# KITITITAS COUNTY

### MEMORANDUM

TO: All Staff  
FROM: Justin Turnbull, County Surveyor   
DATE: May 20, 2021  
SUBJECT: County 2<sup>nd</sup> Survey Review of Final Cluster Plat LPF-20-00005 (Forest Ridge Ph1)

FOREST RIDGE - PHASE I PERFORMANCE BASED CLUSTER PLAT		
PREPARED FOR FRPP PHASE I, LLC A PORTION OF SECTION 24, TOWNSHIP 20 NORTH, RANGE 15 EAST, W.M.		
KITITAS COUNTY		WASHINGTON
DWN BY	DATE	JOB NO.
T.S.	05/2021	18069
CHKD BY	SCALE	SHEET
M.K.K./D.L.P.	1" = 500'	3 OF 7

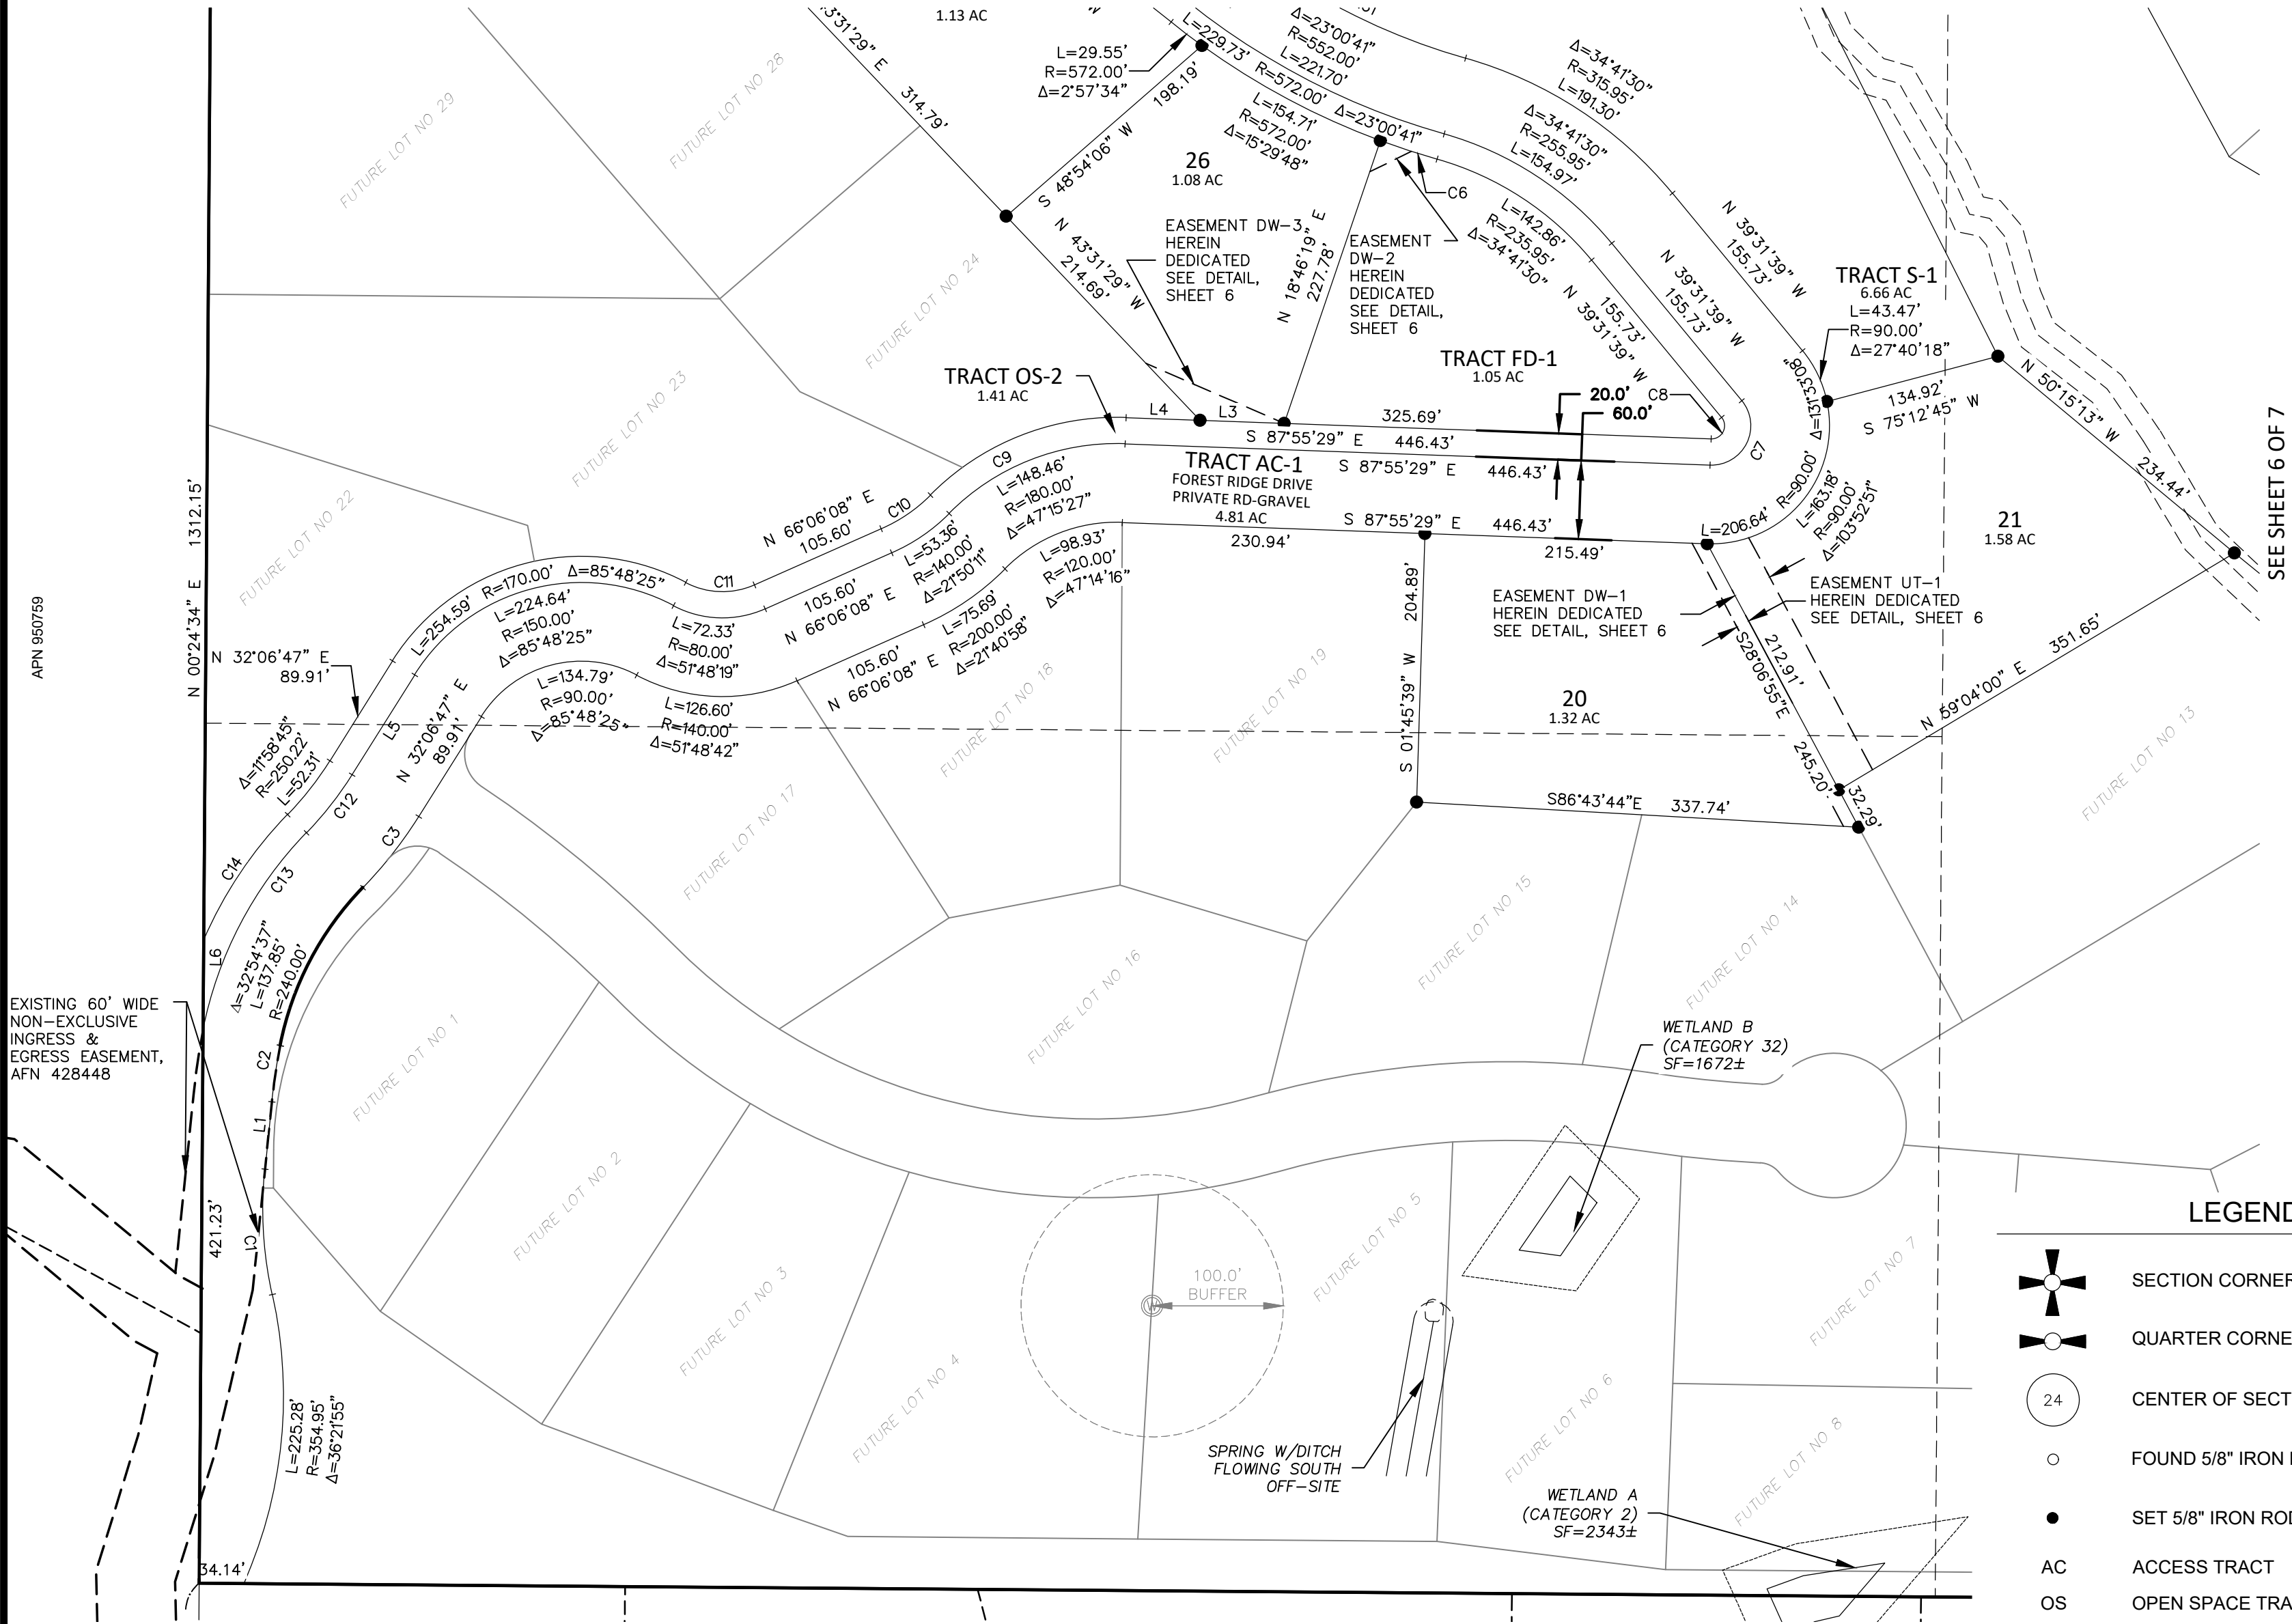
1. The outer plat boundaries and section lines deviate from the record document referred to in the legal description (SUR:31-224). While it is possible that the record document contains errors, there are some particular areas of concern in the submitted Plat:

- a. The West line of Section 24 was evenly divided per SUR:31-224. Dimensions shown on the plat are not an even division. It is possible that the surveyor held found corners, but this is not identified as the reasoning behind the discrepancy.

- b. The East boundary line of Section 24 is recorded as being a straight line from NE corner to SE corner. The East quarter corner was not recovered during the course of this survey. The surveyor has elected to put an angle point in the section line at the NE corner of the SE 1/4 SE 1/4. The existing found evidence was called out as being off. What is the justification for angling the section line at this point, particularly in the absence of suitable corner evidence?

- c. The corner mentioned in change 1b. listed above is called out as being 1.2 feet off. With the section corner calls varying from record by as much as 0.44 feet, it is uncertain as to what evidence was held as control to determine the bearing and distance to the found corner at this location.

- d. The south line of the original division as shown upon SUR:31-224 had an angle point at the N-S centerline of section. The application shows no angle point, and the resulting line falls about 1.4 feet north of calculated position. What is the justification for the change in the line? Was there found evidence that is not mentioned?

- e. The SW corner of SUR:31-224 has also been revised from record to show an angle point in the section line, based upon found evidence. What is the justification in holding this evidence and changing the lines of record vs. calling the found corner as 0.14' off?

9. The N'most curve on the East line of AC-1 does not match the closure report.
10. As the Legal description identifies all the area as shown within the bold boundary on Sheet 3, the remainder area should be identified as a Lot or Tract, and area shown.

11. While it is Public Works opinion that Open Space Lots do not need to have corners staked, under the current configuration, it gives the appearance that Tract OS-1 is bounded by the outer plat boundary which WOULD need corners set. If comment #10 above is addressed, then Tract OS-1 clearly falls inside the plat boundaries and corners would not be required.
